Agenda Item: Construction Traffic and Access

From [REDACTED], Gt Staughton Parish Council [REDACTED]

Figure 2-5 Indicative Construction Access and Compounds (Rev P01)

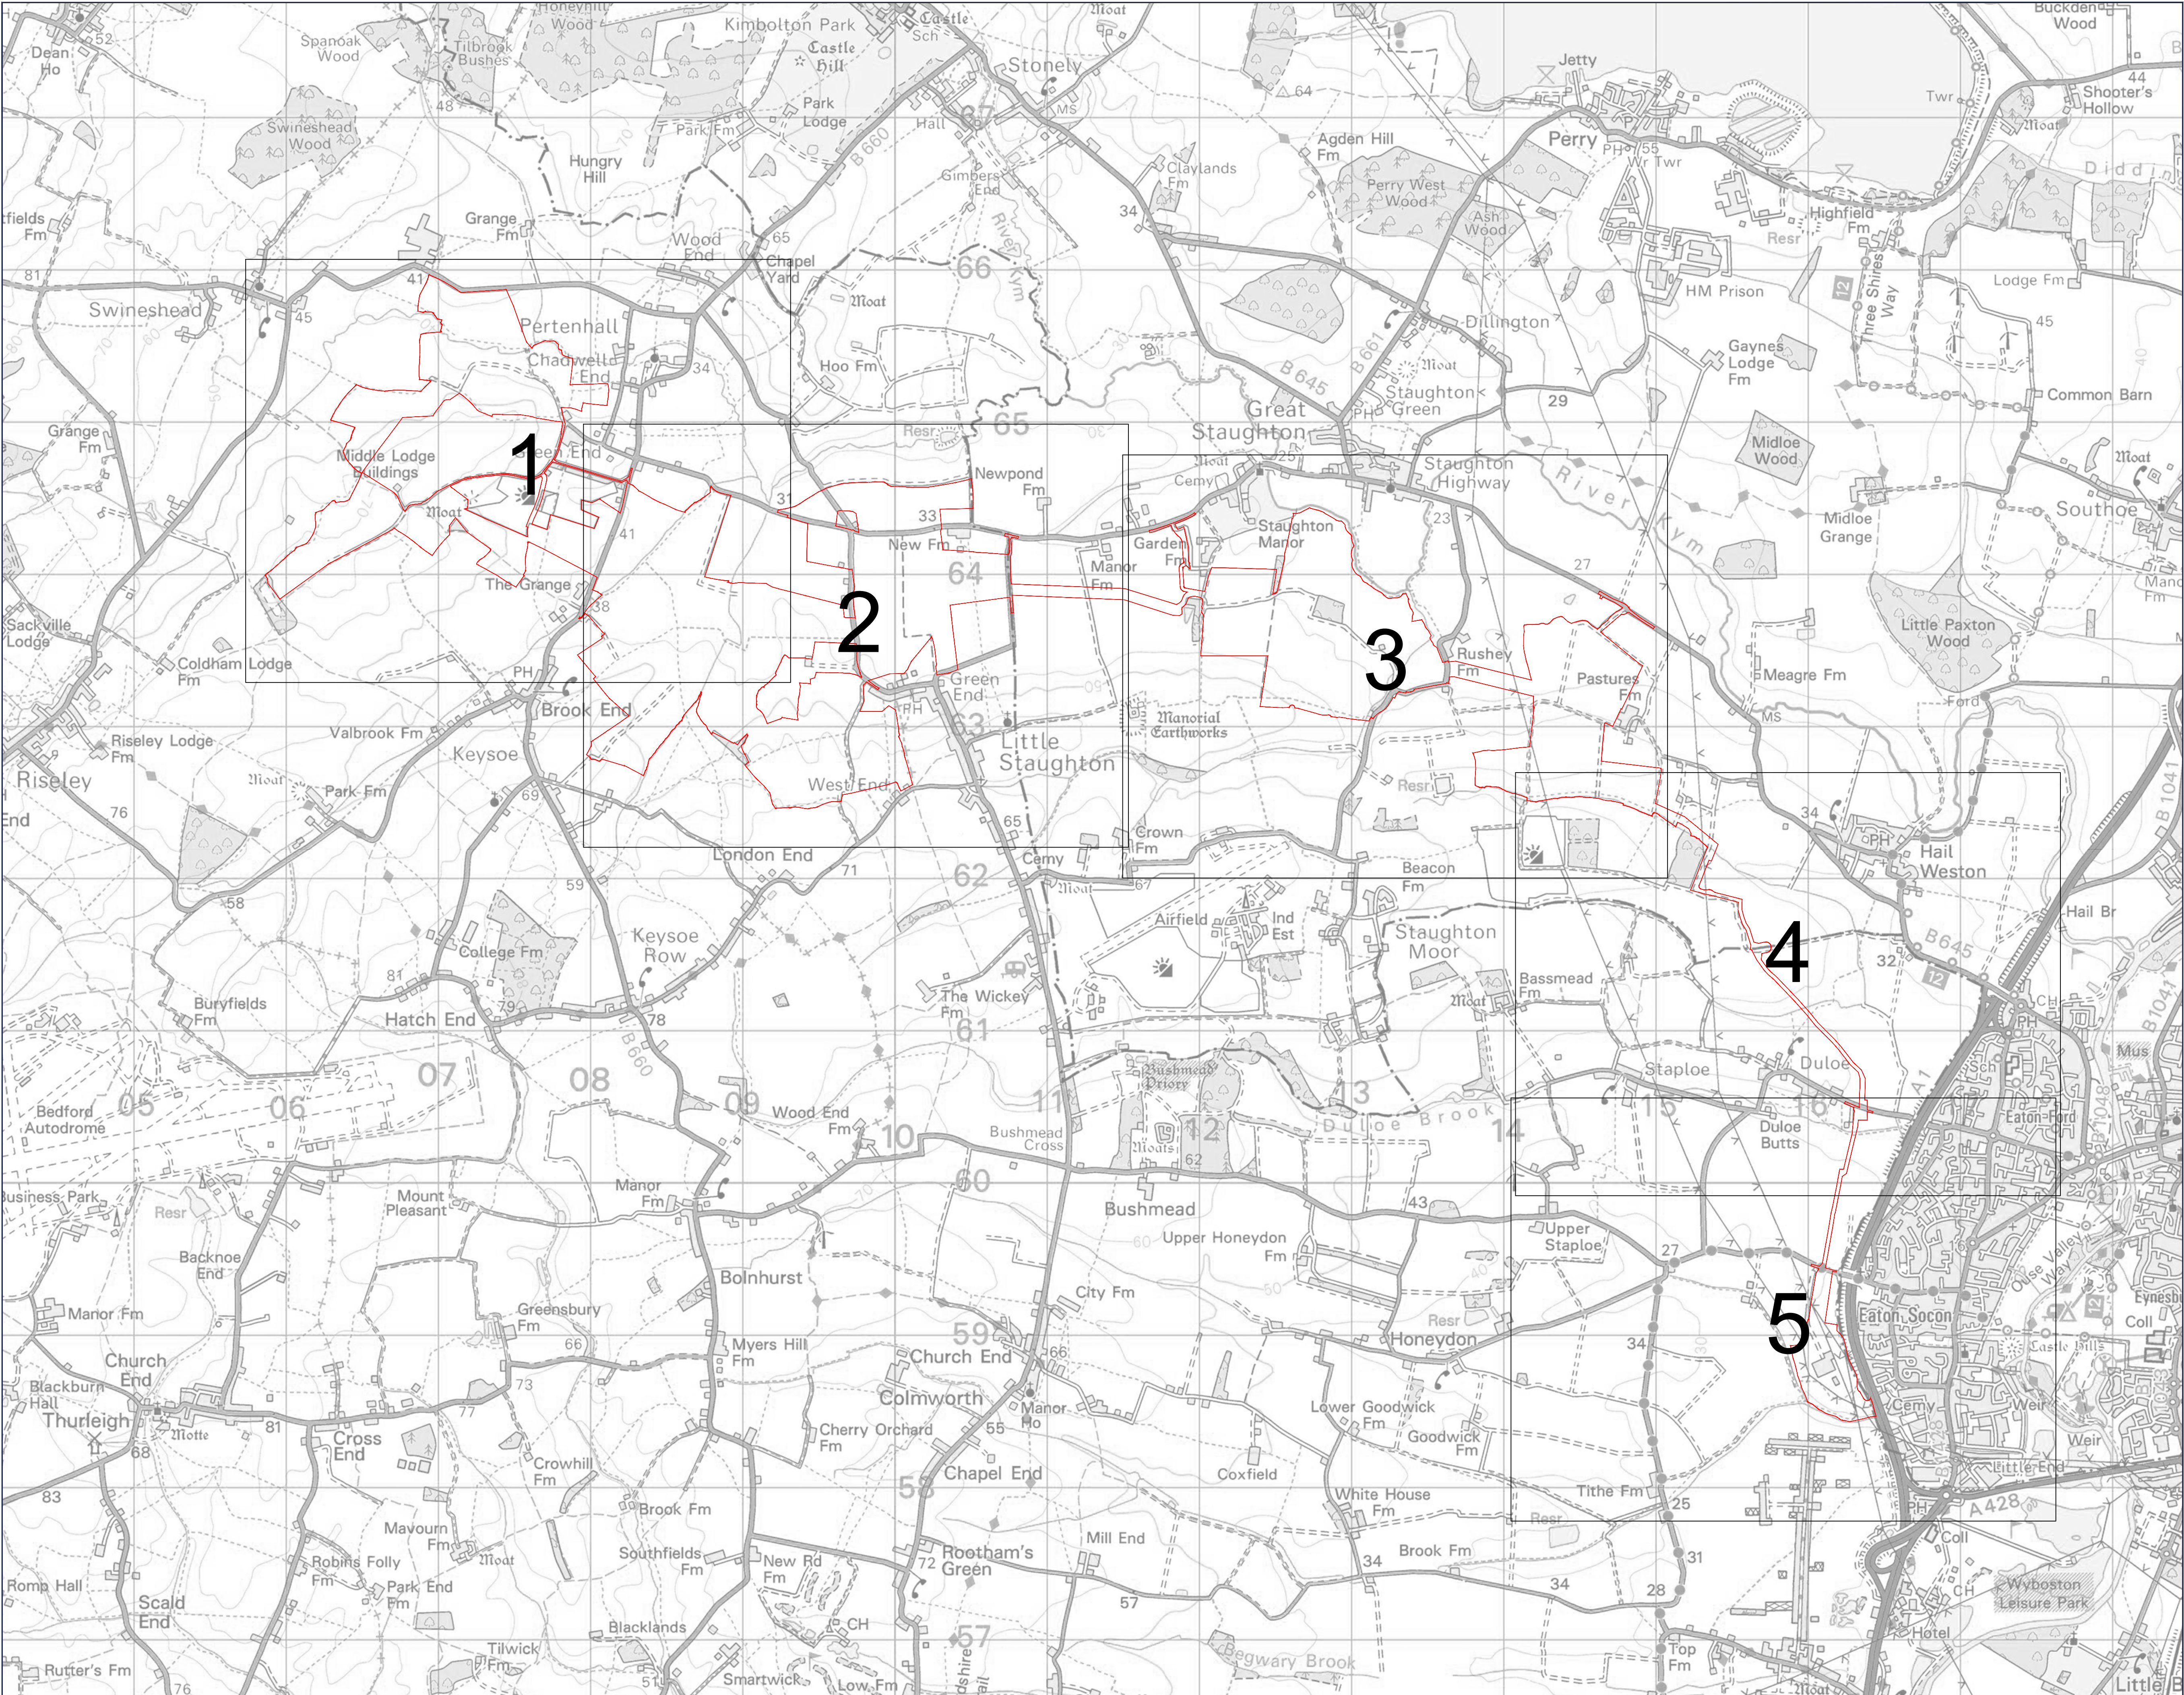
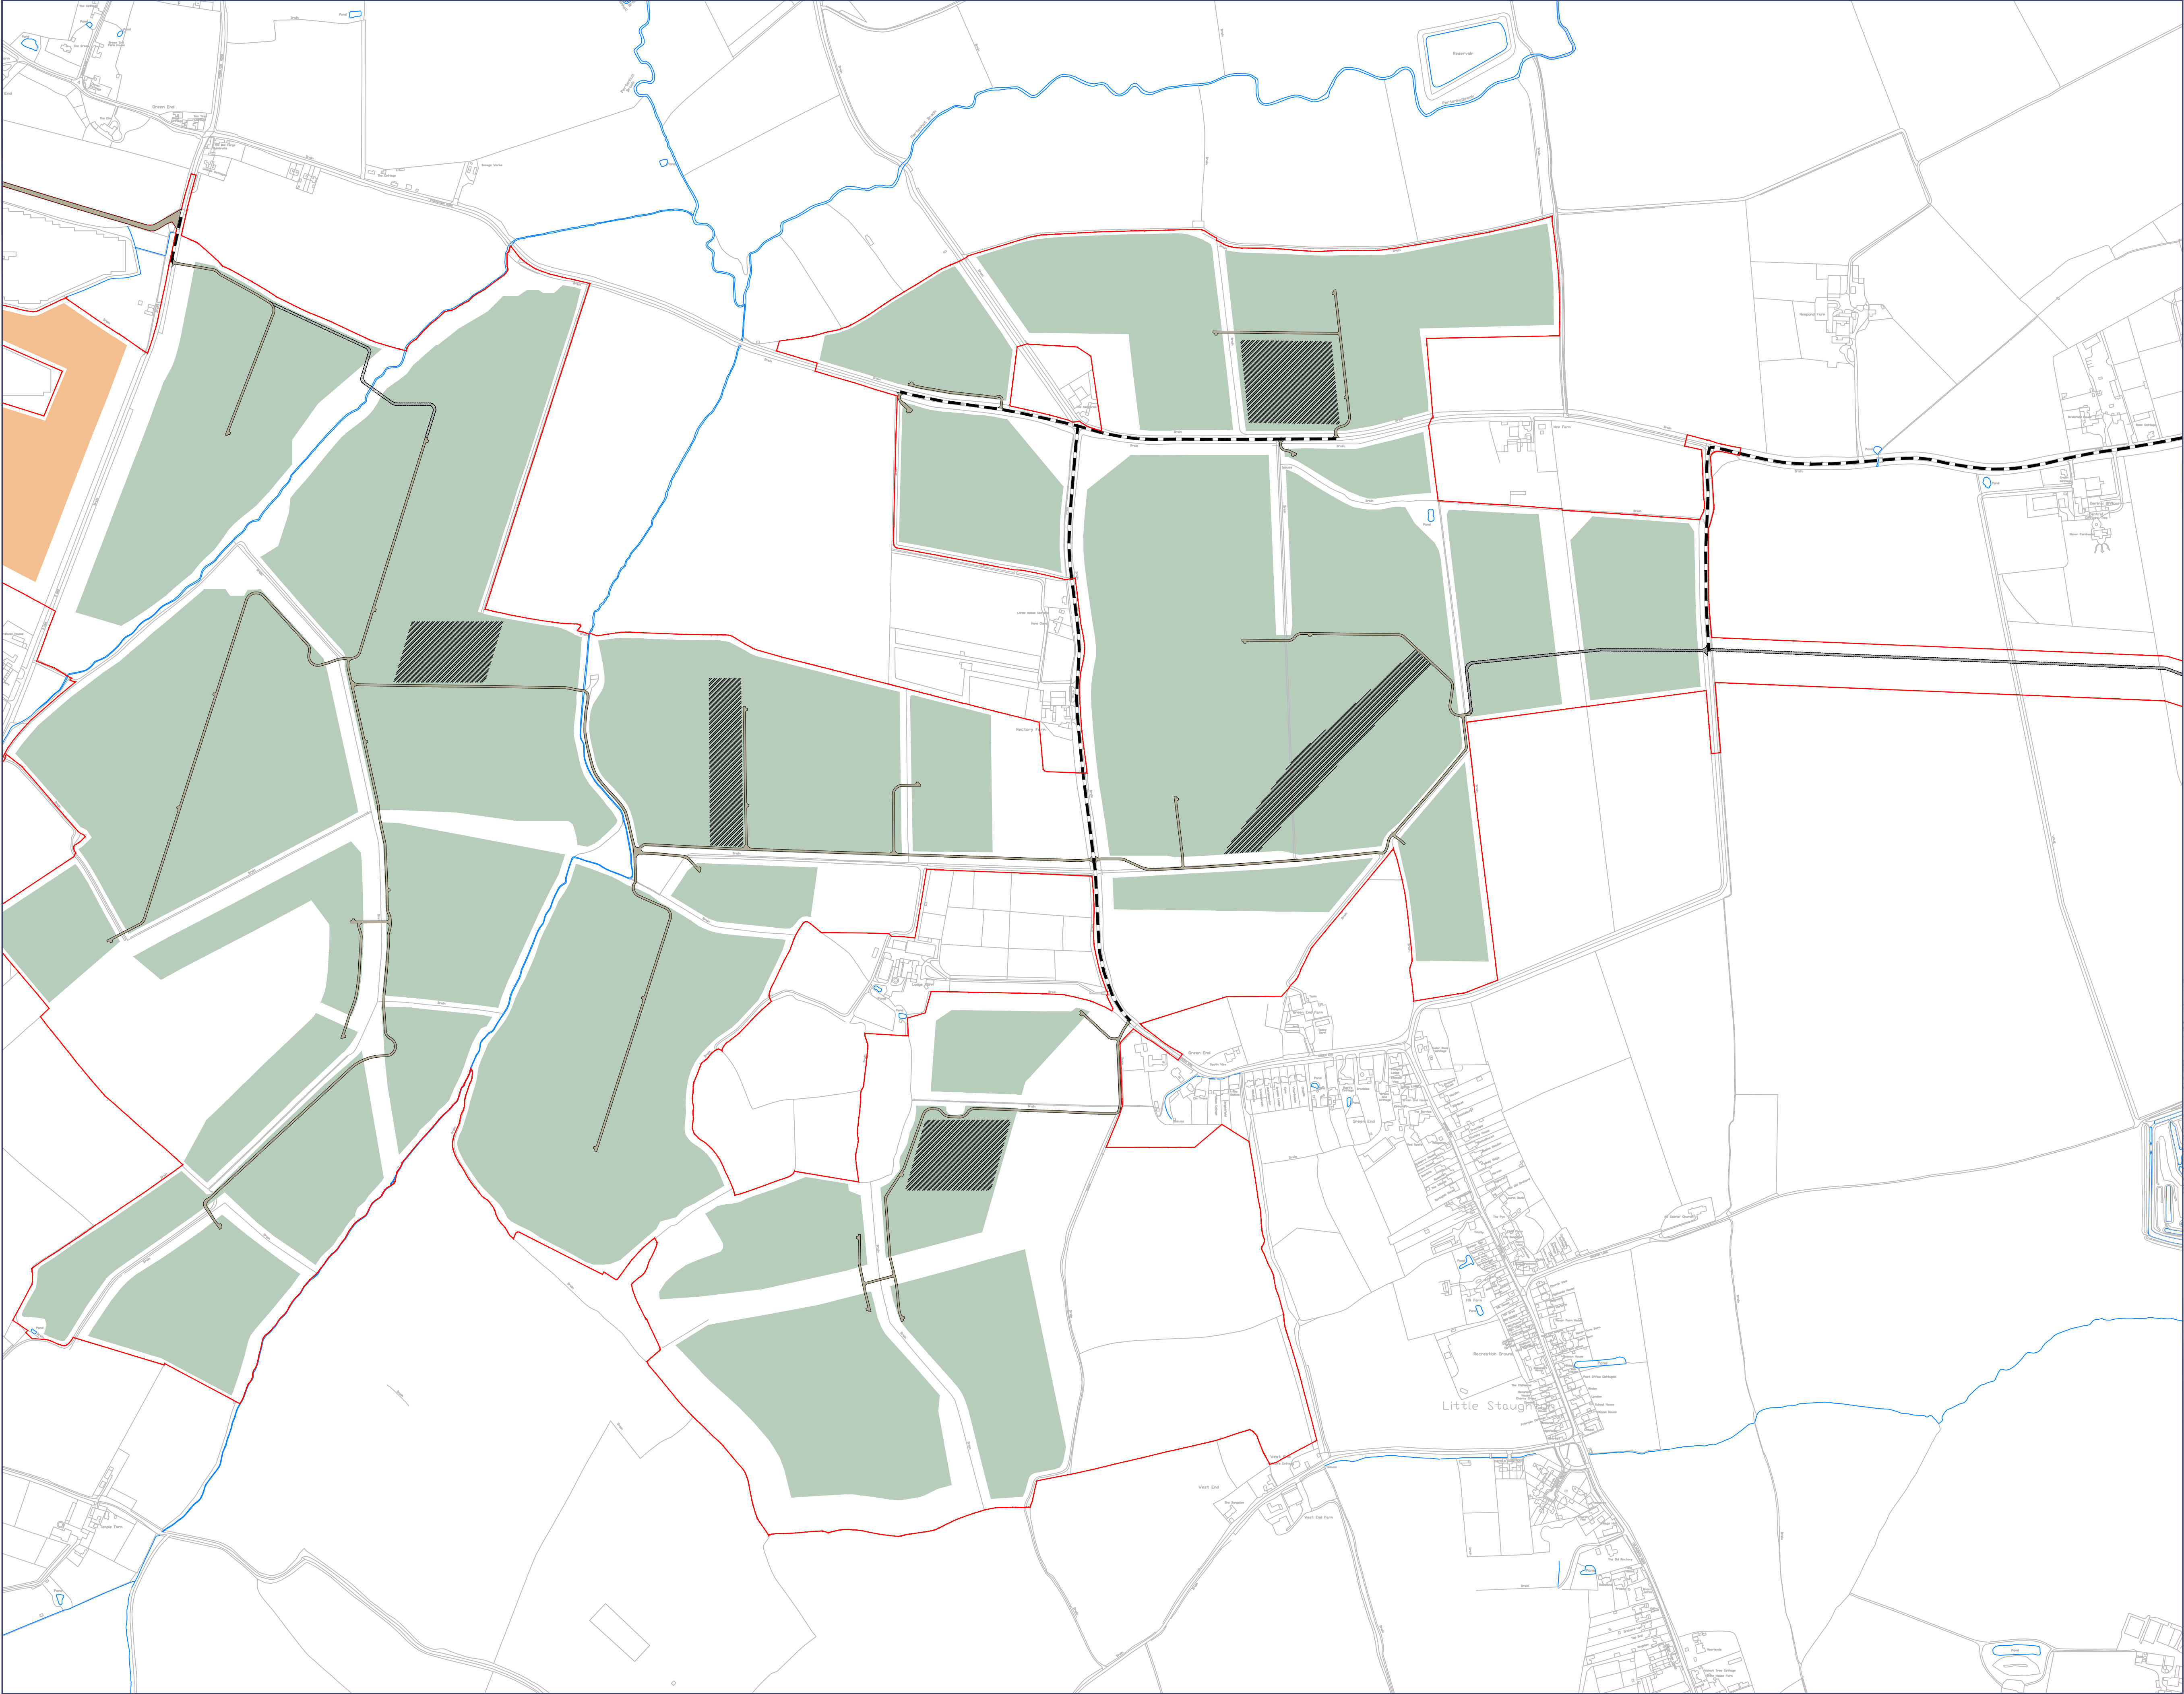
We understand that Brockwell's intention is for all the site traffic to come from the A1 along the B645 and enter the point at SA16. However, we would like to see a commitment that this will be strictly enforced otherwise we suspect that construction traffic including HGVs will be tempted to take the shortcut from SA12 back through the village in a way that would be exceedingly dangerous and disruptive:

B645 (MAIN ACCESS SA16 to site D). This stretch of road is considered locally to be extremely dangerous:

Gt Staughton Road towards Pertenhall, around SA12 and the Zantra site

This minor road is not suitable for HGVs, being barely more than 5m of tarmac wide in some places, with two passing HGVs requiring **5.7m** of width to clear their mirrors safely. Also the use of this stretch of road will make it very tempting, without very

strict enforcement, for construction traffic to take shortcuts through the village. It would be better if this stretch of road was not used at all for construction traffic.

We are concerned that the project will cause obstruction on the B645 (especially around the main site D access SA16) which is the route to and from work school and shops for many parish residents. Any blockages, hold-ups or temporary traffic signals will come at a significant economic and social cost to local residents.

We are concerned that the proposed access route appears to travel over the newly designated Roman Town Scheduled Monument, with cable trenching potentially under it. To avoid risk of damaging the monument, it would be better if the access route and cabling should be kept well away from the monument

2. **A Pre-Commencement Road Survey:** A legally binding 'Section 106' agreement for the developer to repair all road and verge degradation.
3. **A Physical Width Audit:** A requirement for the Applicant to prove, via 'Swept Path Analysis', how two HGVs can pass on Pigs' hill on the B645 and on Great Staughton Road without leaving the tarmac."

4. **Construction Traffic should not use the 'Gt Staughton Road'**, and instead should keep to a purpose built access track off the road network
5. **Construction Traffic and cabling should be kept well away from the scheduled monument.**
